Mr & Mrs S. Williams
Spindrift
South Strand
East Preston
BN16 1PN

24th July 2012

Ref EP/70/12

1207 SK23
Sandgate House, East Preston
First Floor As Proposed
June 2012
scale: 1:100

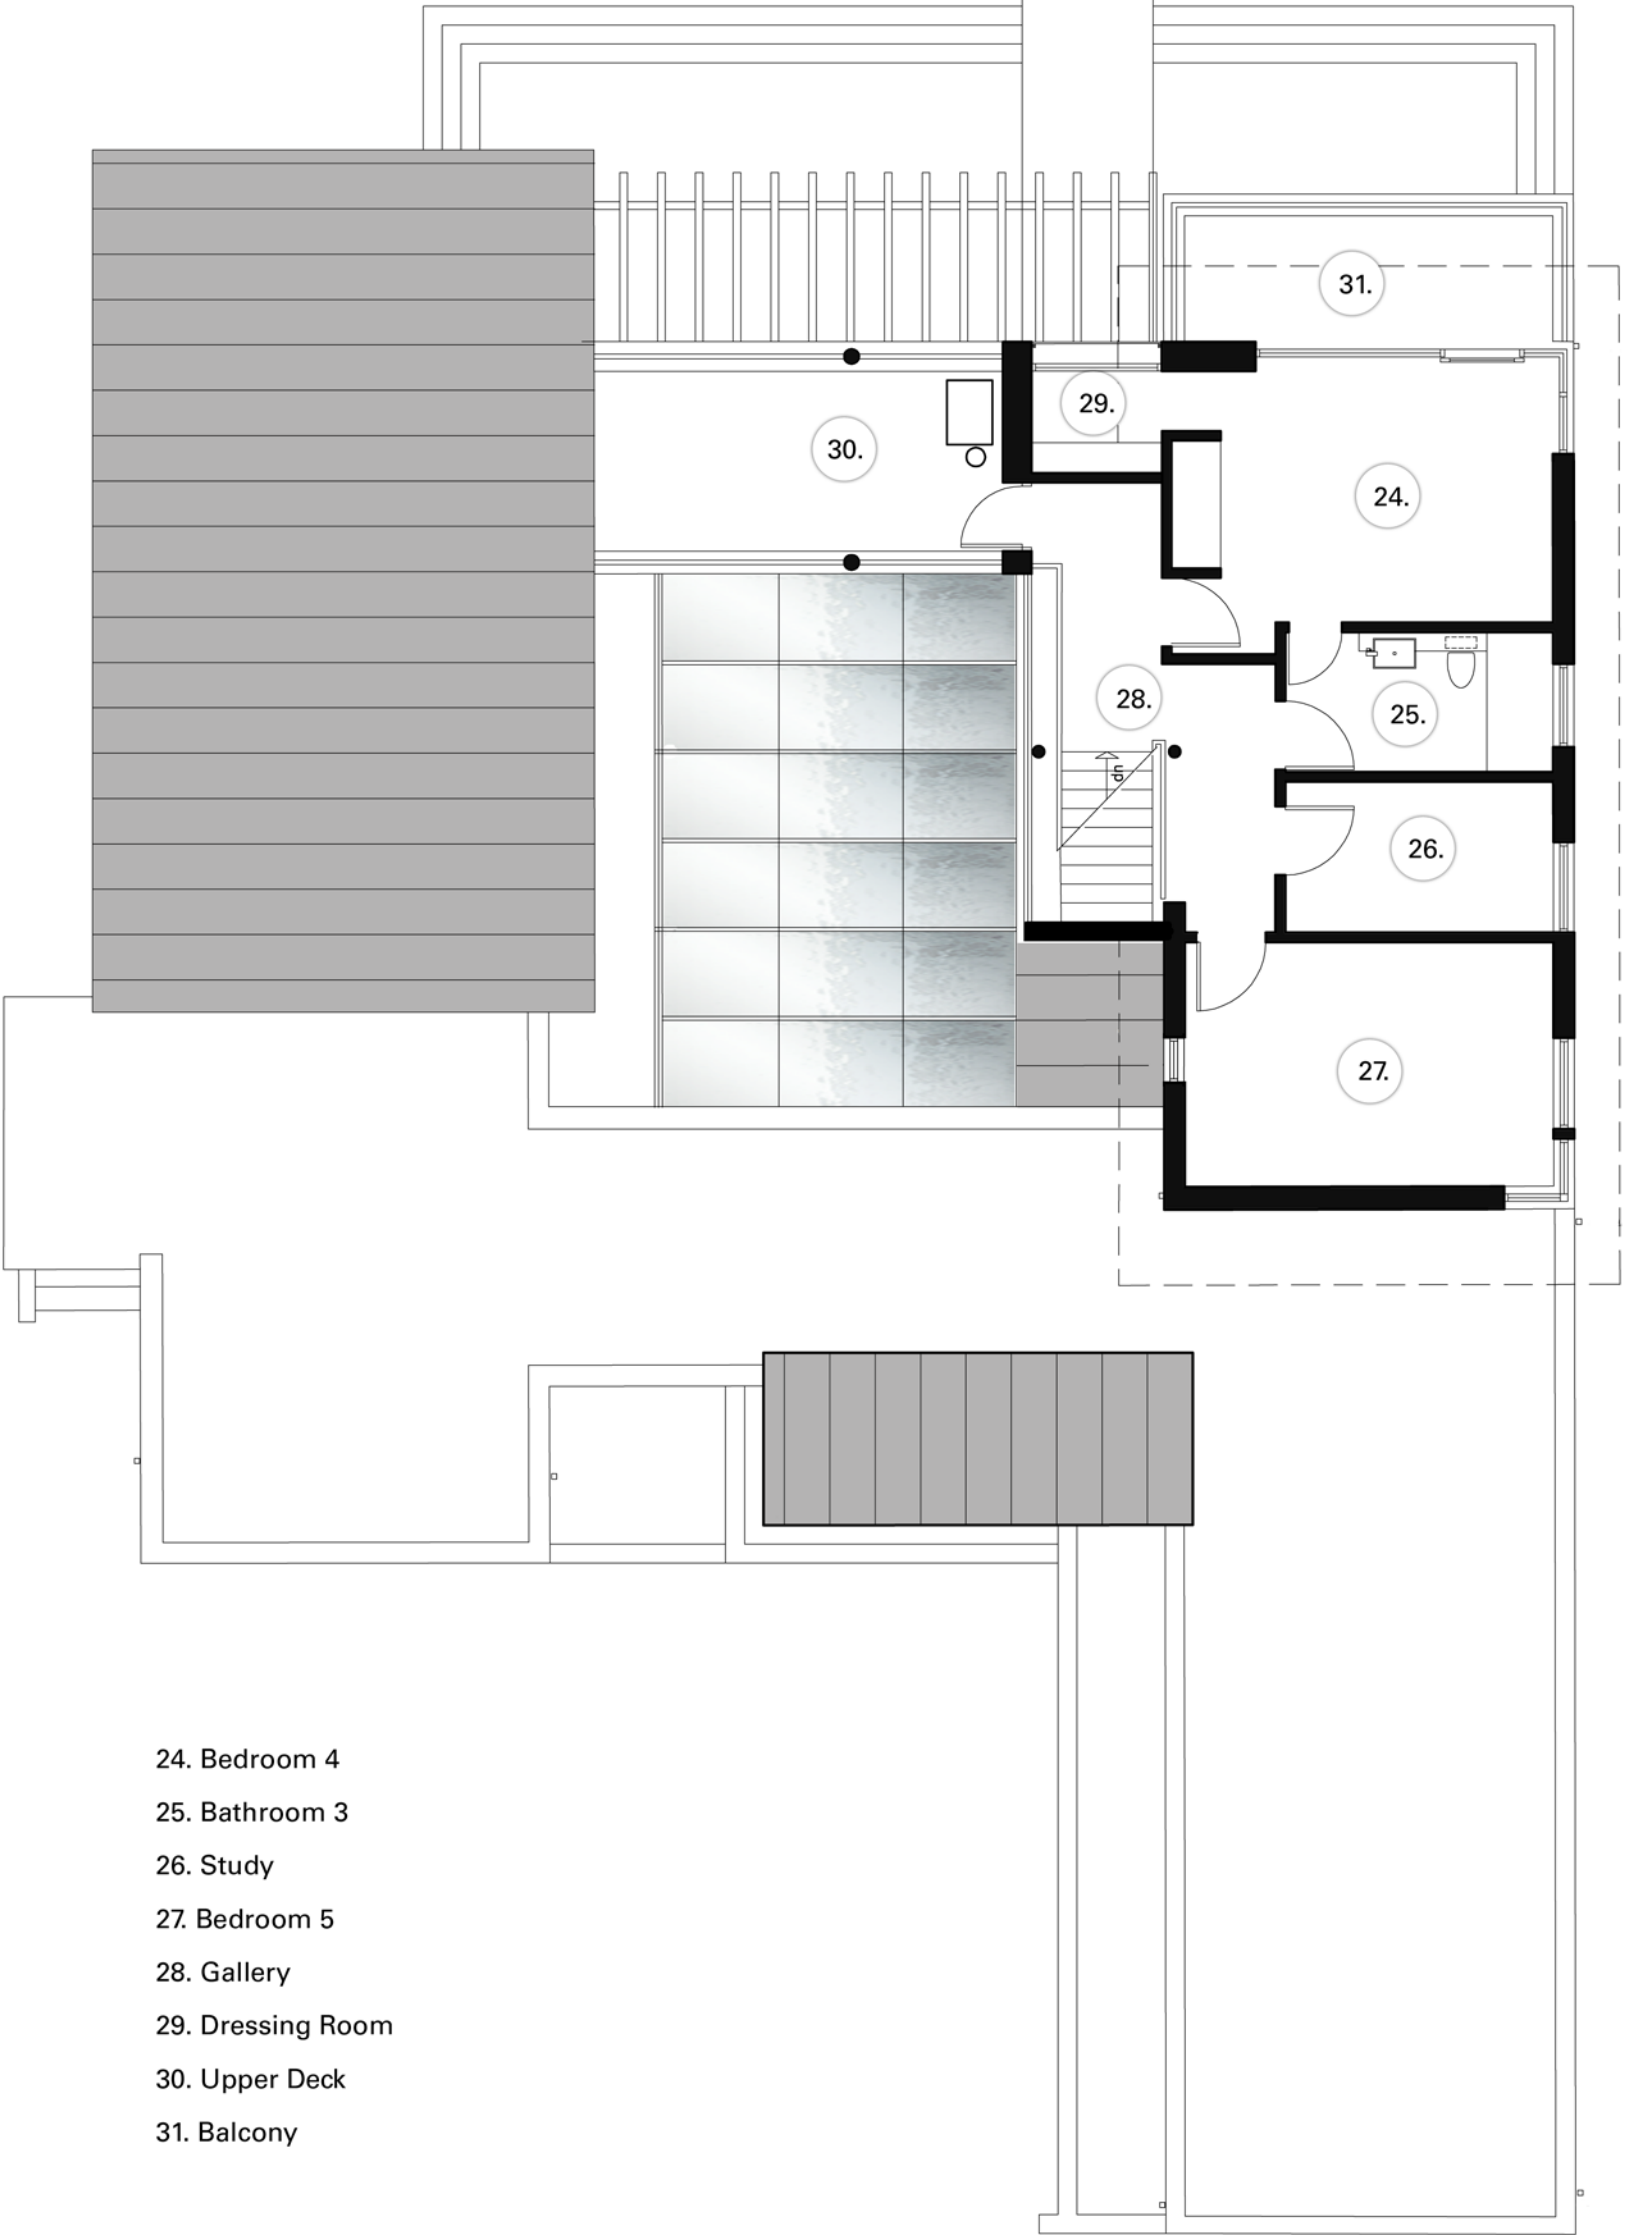
1. The proposed first floor extension by reason of its design, scale and appearance fails to appear to visually integrate or be equal to the existing low level beach scene that exists currently.

Historically, with regards to other applications in this area, planning has sought to maintain the low level, ground floor level beach scene which runs from the sailing club to past Sandgate House, all with pitched roofs. The nature of the proposed design, which allows for a new raised structure on the west and south west corner would take the existing height from 2.6m on the west side rising away at a pitched angle to 4.4m in overall height, to a new solid height rising directly up on the south and west side to 6.2m. This flat roof structure at 6.2m rises back along the west elevation for 10.6m and provides a mass that is heavy and imposing to the beach scene and other properties (both behind and to the side).

1207 SK26
 Sandgate House, East Preston
 Elevations As Proposed - sheet 2
 June 2012
 scale: 1:100

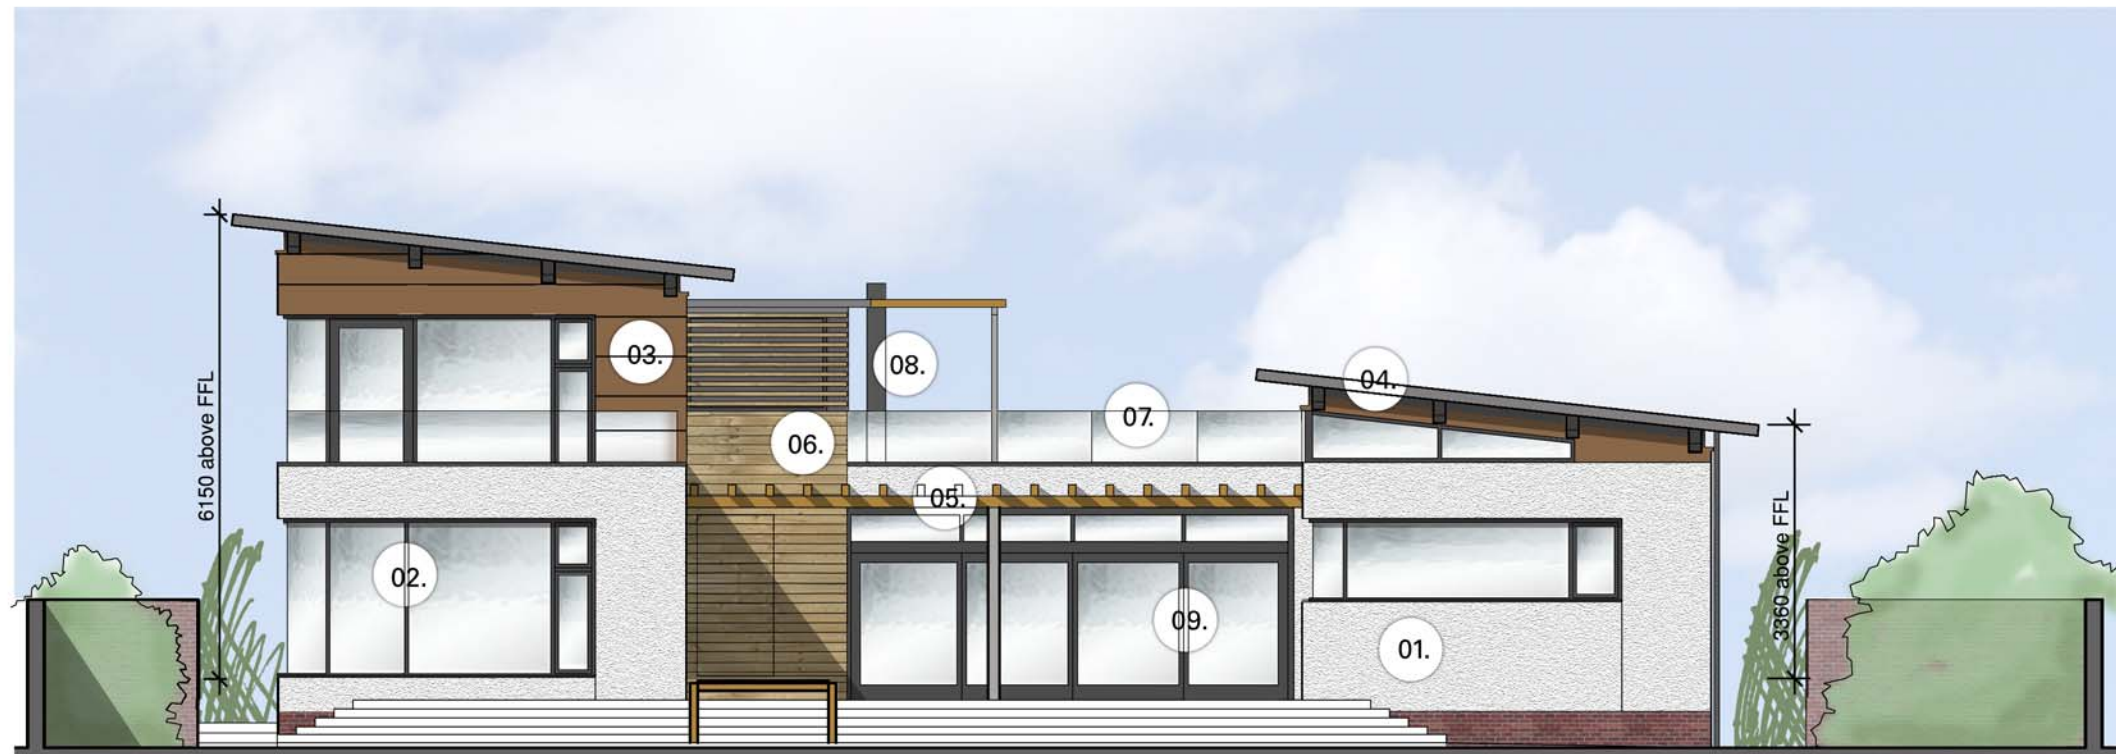
The application (conclusion in DAS) is extremely light in its emphasis on this first floor structure and skirts over it. It is also noted that the beach scene montage, while itself a useful document, is taken from the South East (a number of properties along to the east of Sandgate) and therefore projects a reduced impact when it looks back at Sandgate House. This scene is also not the same as the photo model visualisation which, with the removal of the greenery, makes the house more prominent and imposing. Due to the fact that Sandgate sits at a south east angle on its plot the proposed introduction of this first floor from the south beach scene, south west and west is very marked. This has not been shown in the plans.

1207 SK25 A
Sandgate House, East Preston
Elevations As Proposed - sheet 1
June 2012
scale: 1:100

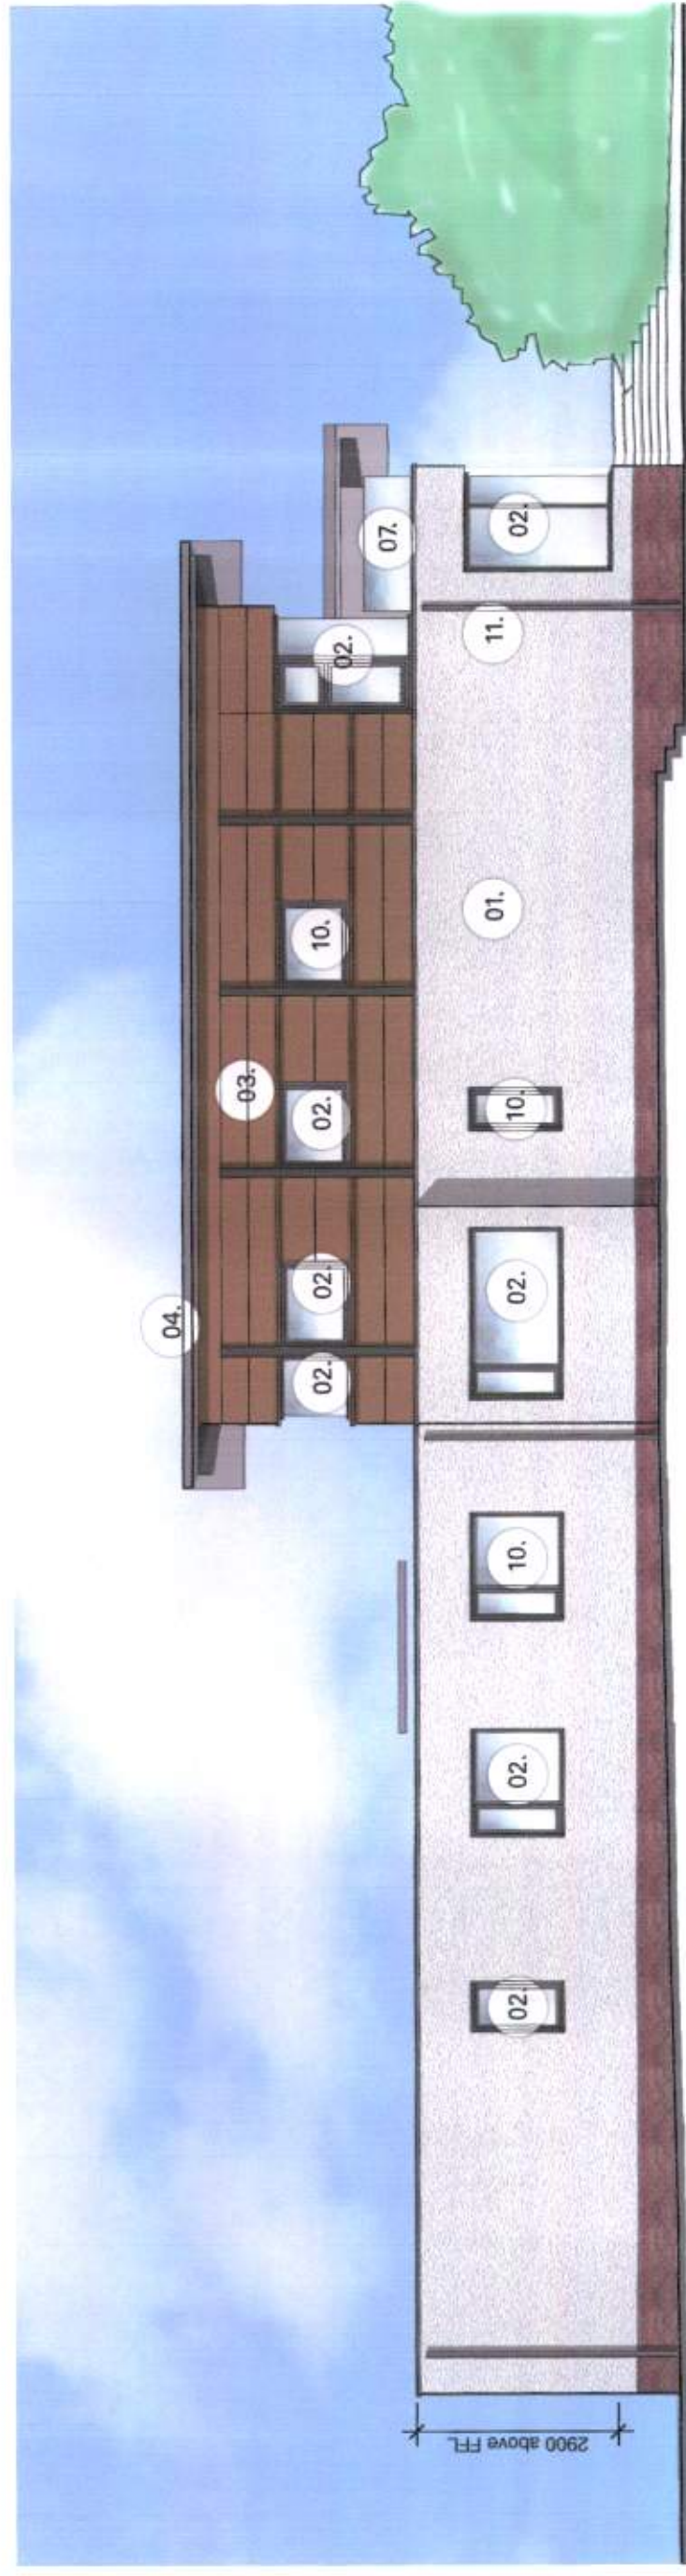
2. The new proposed west elevation has a good deal of windows proposed, as well as a balcony and full length balcony windows/doors. Whilst it is noted that these are proposed to be obscured, windows and doors can be opened and balconies sat on. There is significant overlooking here into the garden on the West and possibly in the North window into the properties behind.
